DRB CASE ACTION LOG (Prel/Final)

DRB Application No.: 09DRB-70165

Project # 1007005

**CITY OF ALBUQUERQUE
PLANNING DEPARTMENT
April 1, 2009
DRB Comments**

**PLAT OF TRACTS A-1 AND A-2 LANDS OF EUFELIA A. GABALDON**  
 WITHIN  
 PROJECTED SECTION 12, TOWNSHIP 10 NORTH, RANGE 2 EAST, N.M.P.M.  
 TOWN OF ALBUQUERQUE GRANT  
 CITY OF ALBUQUERQUE  
 BERNALILLO COUNTY, NEW MEXICO  
 AUGUST, 2008

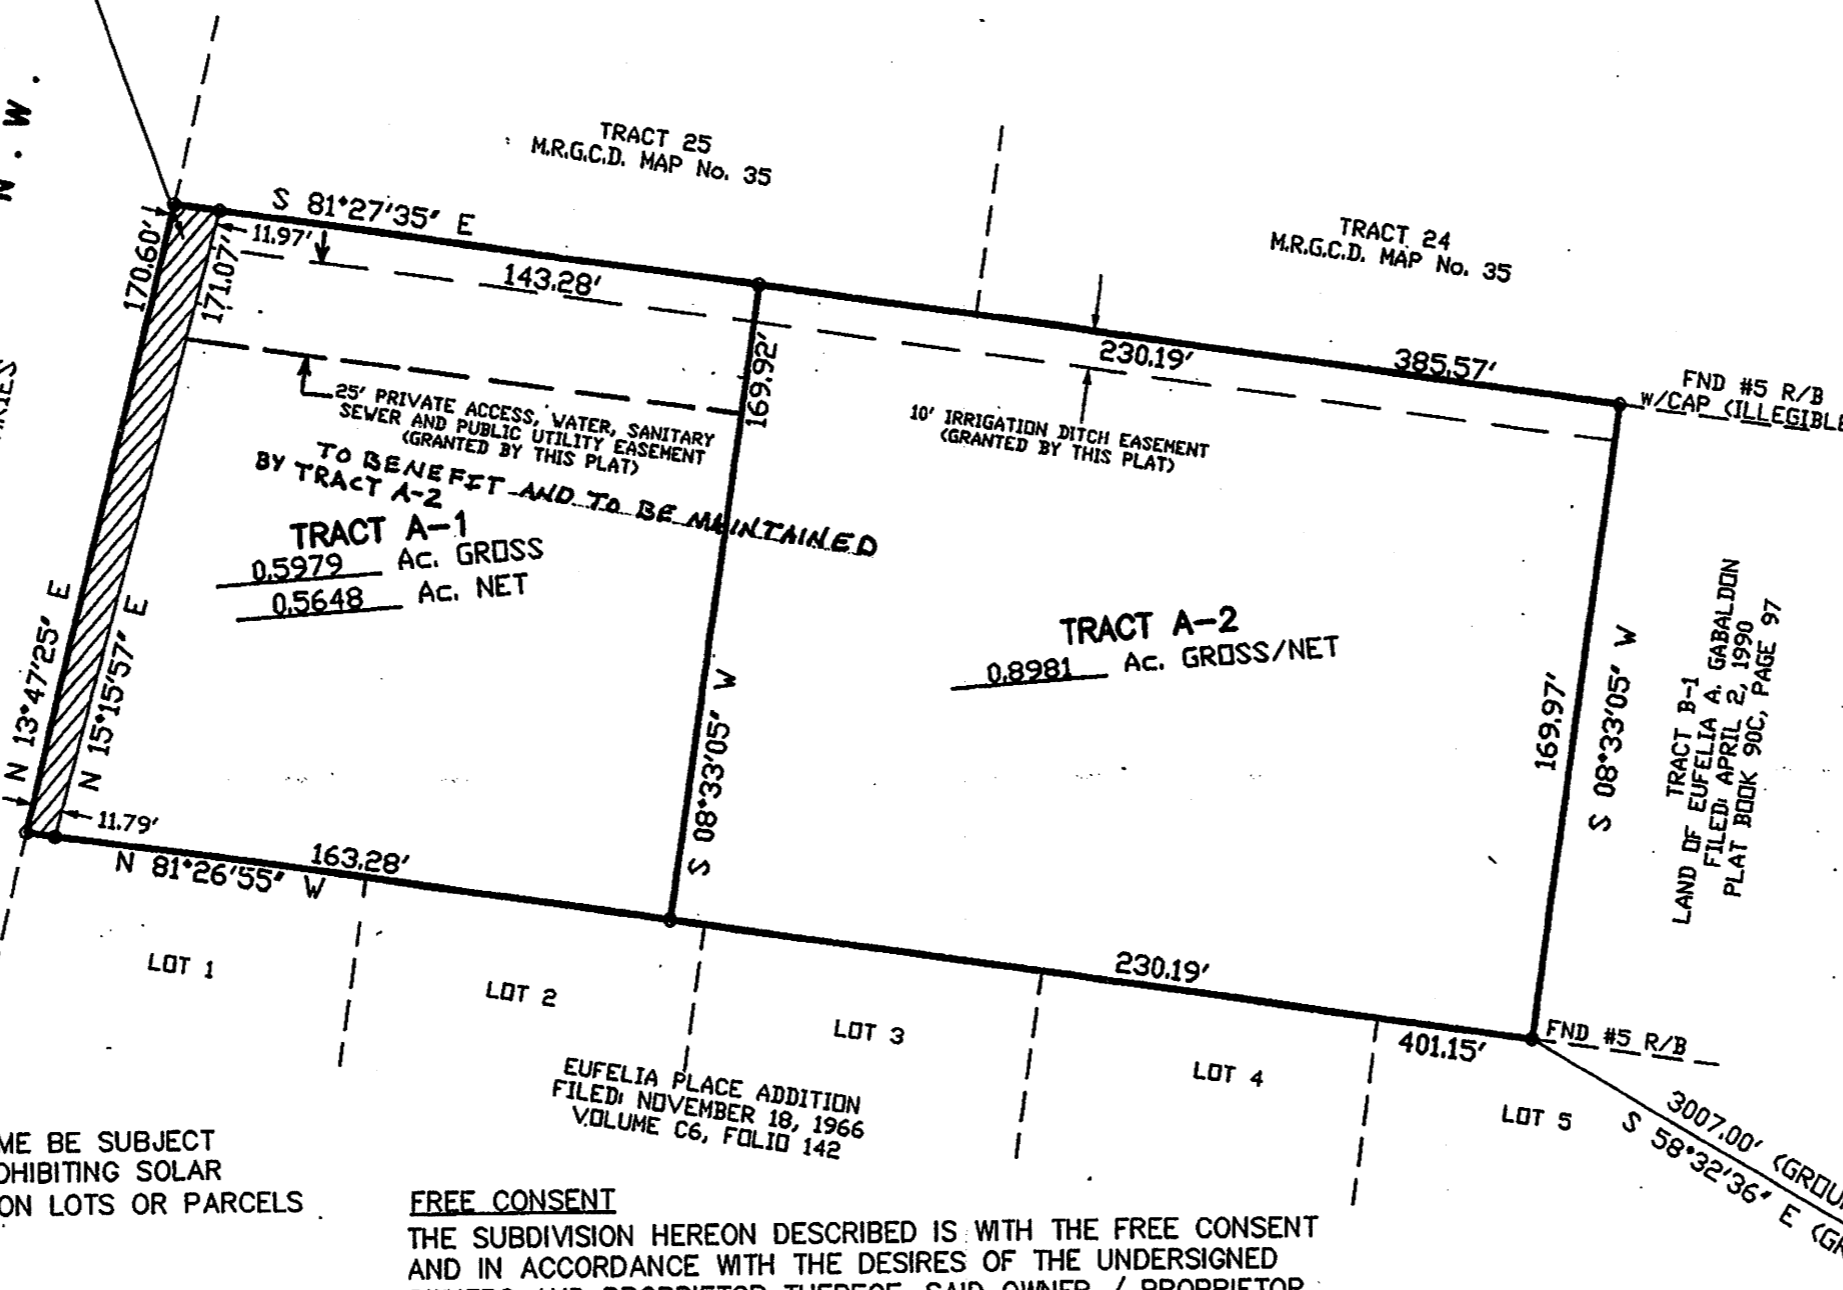
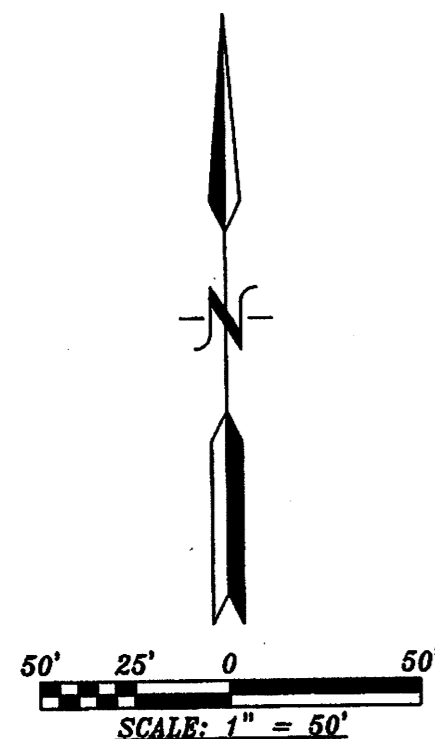
- PLANNING (Last to sign): Maintenance & Beneficiaries of Private Easement - show as no/unde easement

The private easement for the rear lot needs to be separate from the Ditch Easement. Maintenance and Beneficiaries of the private easement need to be identified on the plat – unless a separate, 22 foot easement is provided, the rear lot will not be able to be further subdivided.

**PLAT OF  
TRACTS A-1-A AND A-1-B  
LANDS OF EUFELIA A. GABALDON**  
WITHIN  
PROJECTED SECTION 12, TOWNSHIP 10 NORTH, RANGE 2 EAST, N.M.P.M.  
TOWN OF ALBUQUERQUE GRANT  
CITY OF ALBUQUERQUE  
BERNALILLO COUNTY, NEW MEXICO  
MARCH, 2009

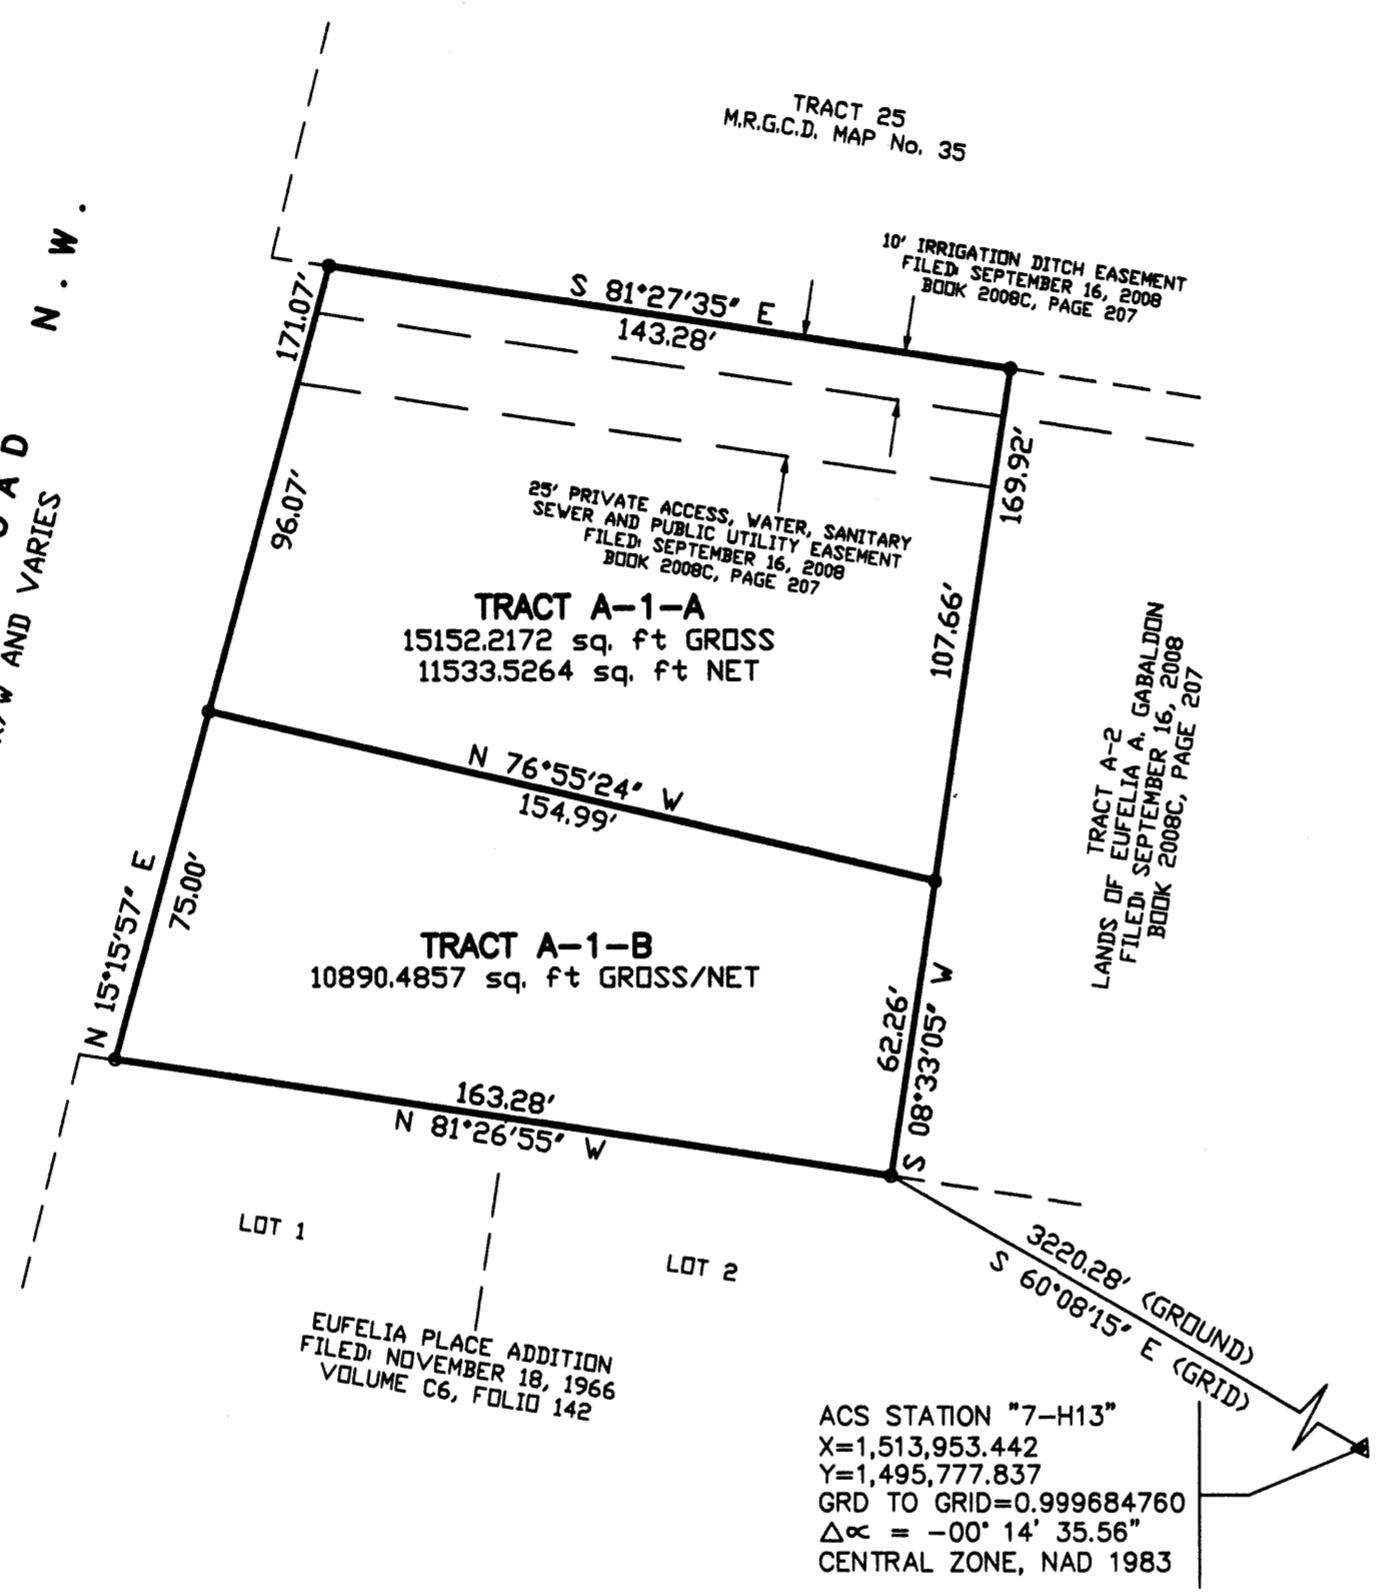
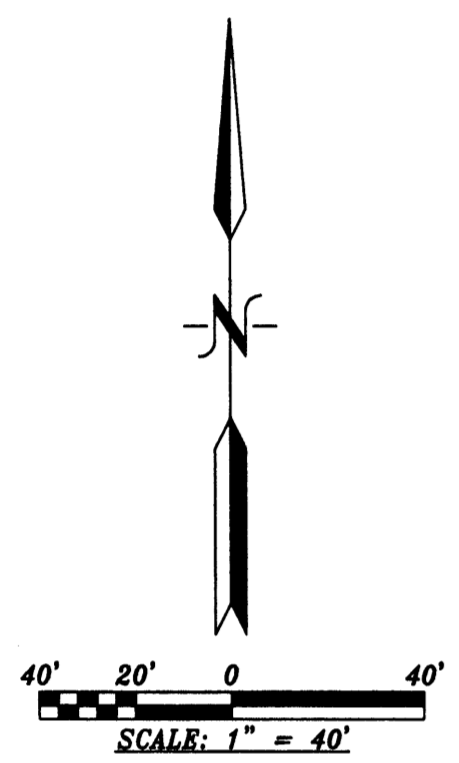
The minimum lot width of the RA-2 zone is 75 feet; per the Zoning Code, lot width is measured 50 feet back from the front lot line – the proposed new lot line would need to be adjusted to meet the minimum width at 50 feet.
